From: Simon Davis
Sent: 13 April 2022 18:24
To: Planning Scanning
Subject: FW: Planning Consultation on: AL/36/22/DOC

From: Simon Davis [REDACTED]
Sent: 01 April 2022 12:20
To: Sarah Sutcliffe [REDACTED]
Subject: Planning Consultation on: AL/36/22/DOC

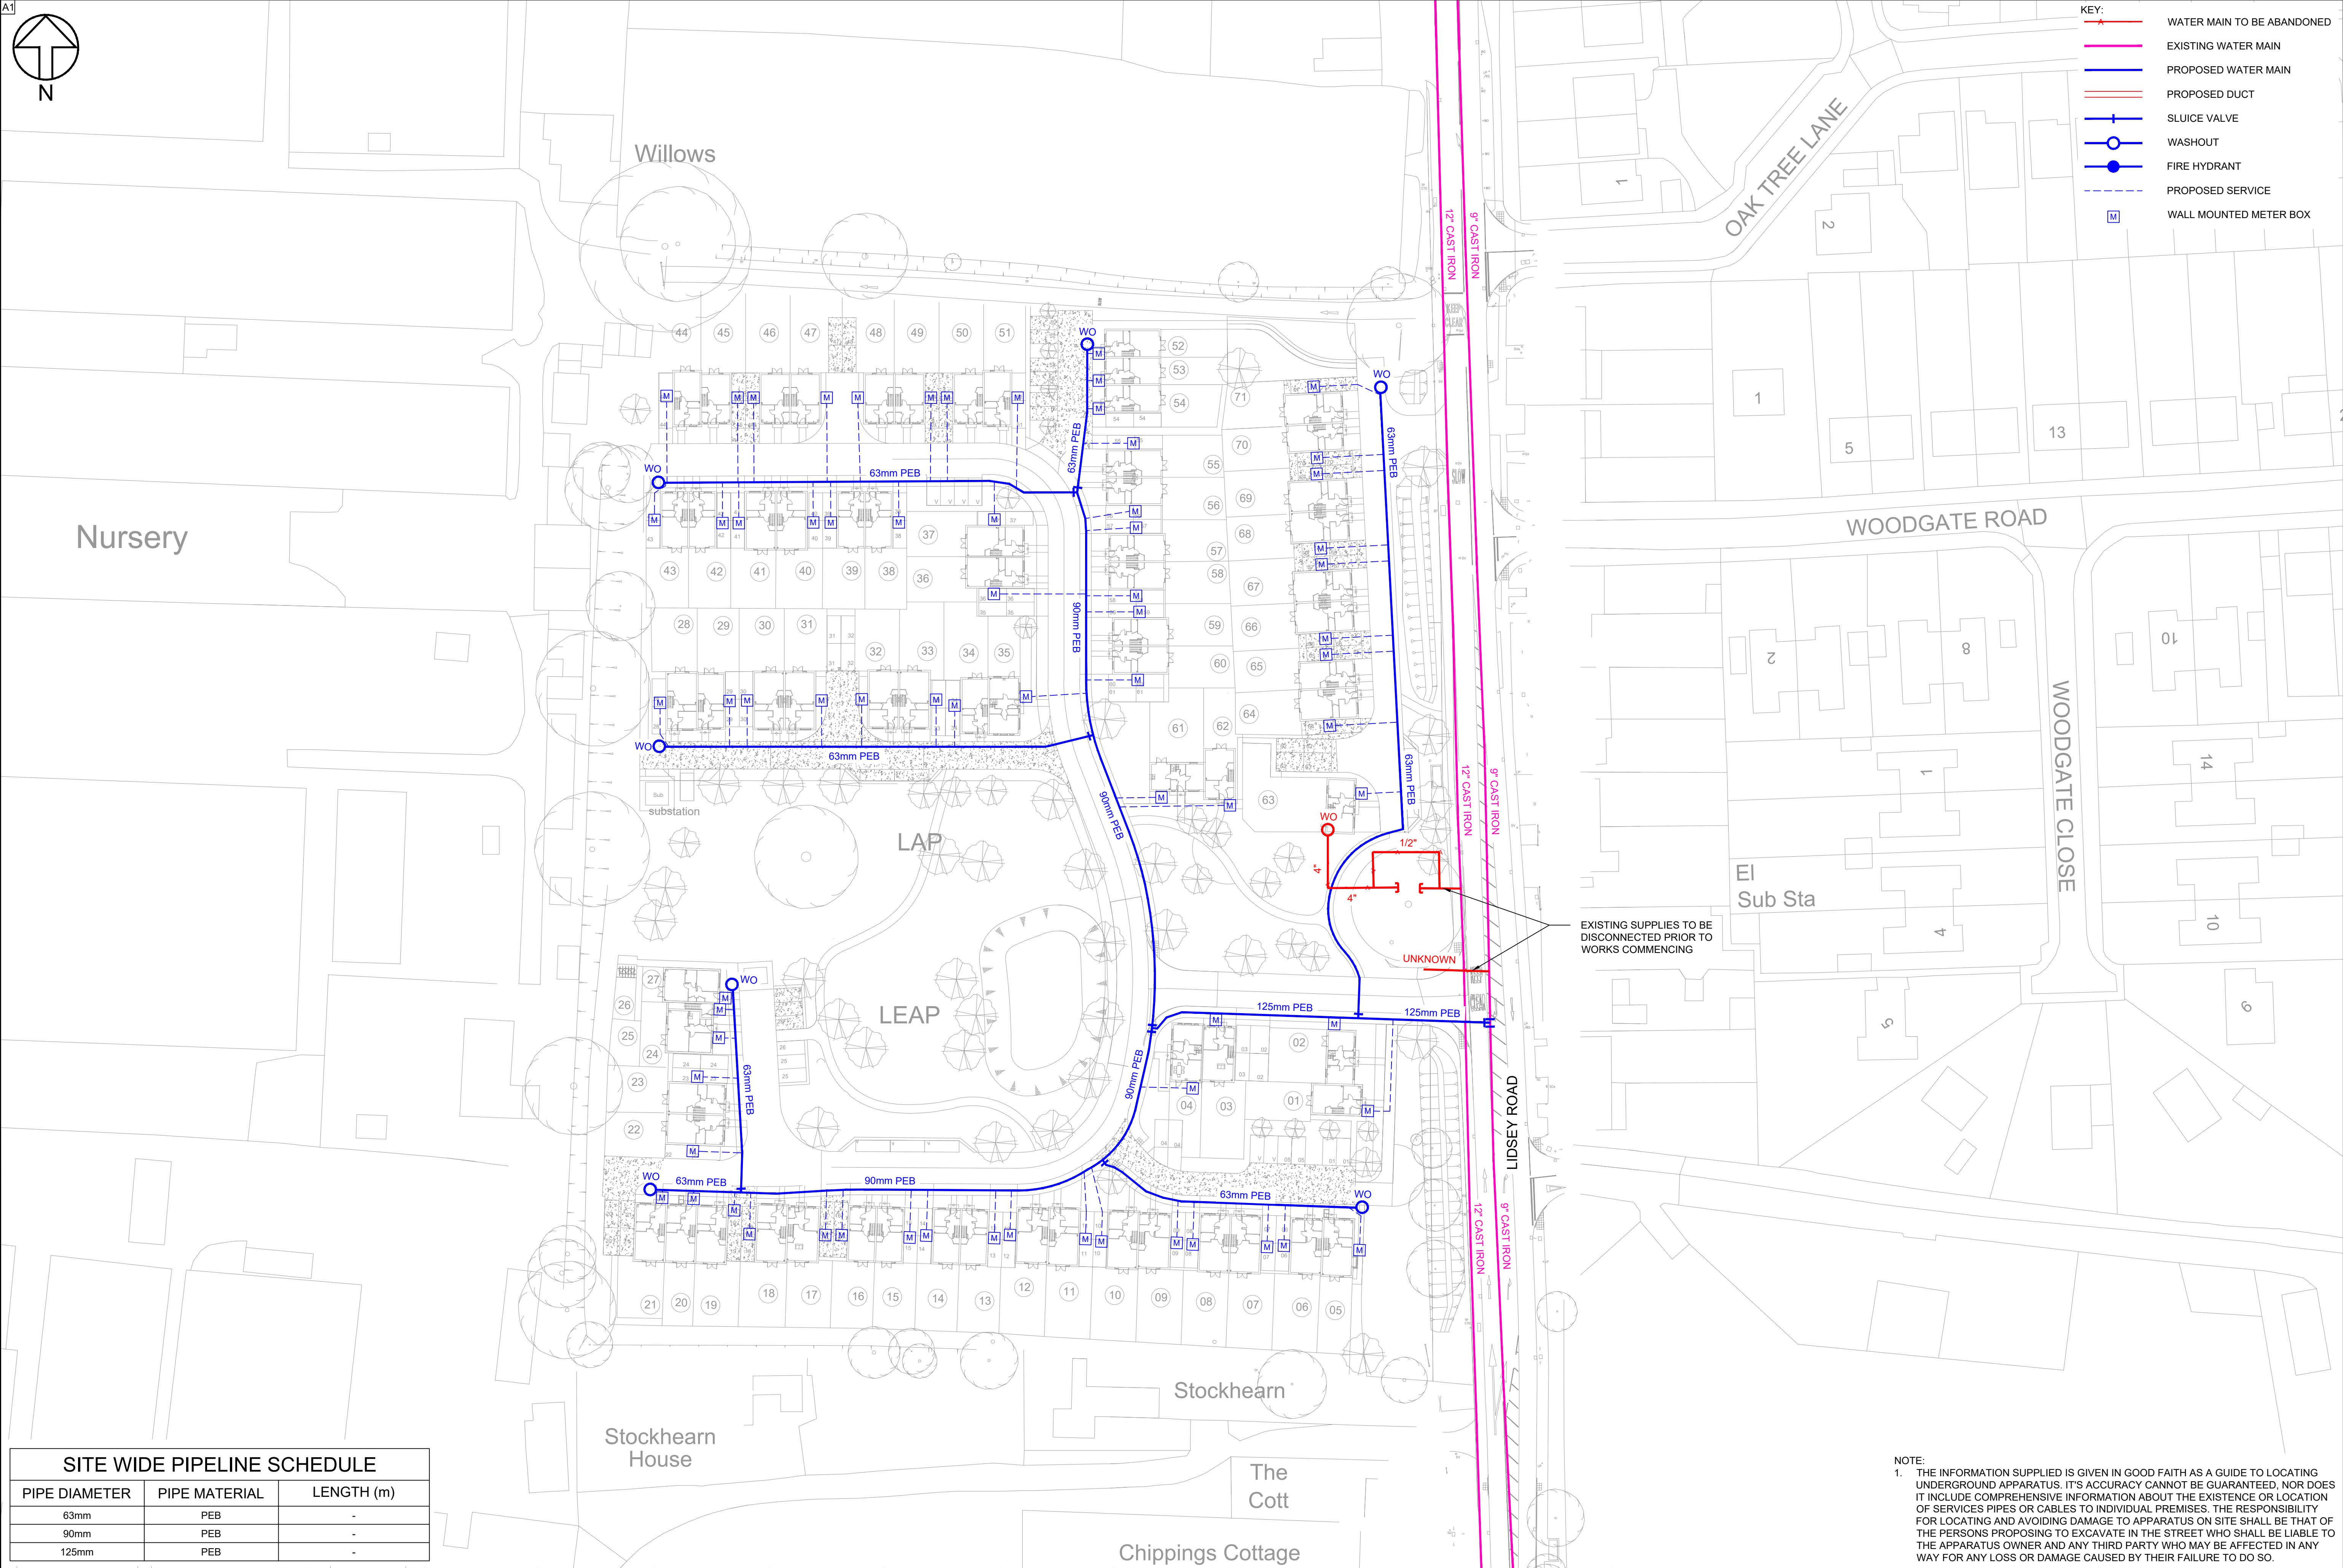
The water main plan submitted does not have any fire hydrant locations indicated and all the wash out hydrants are on 63mm mains. The minimum mains size for a fire hydrant is 90mm, so the mains indicated on the plan is not suitable for supplying any fire hydrants, the mains size is too small. This was consulted

on with the Water Supply and four fire hydrants were required. Therefore the fire hydrant condition has not been met and should not be discharged.
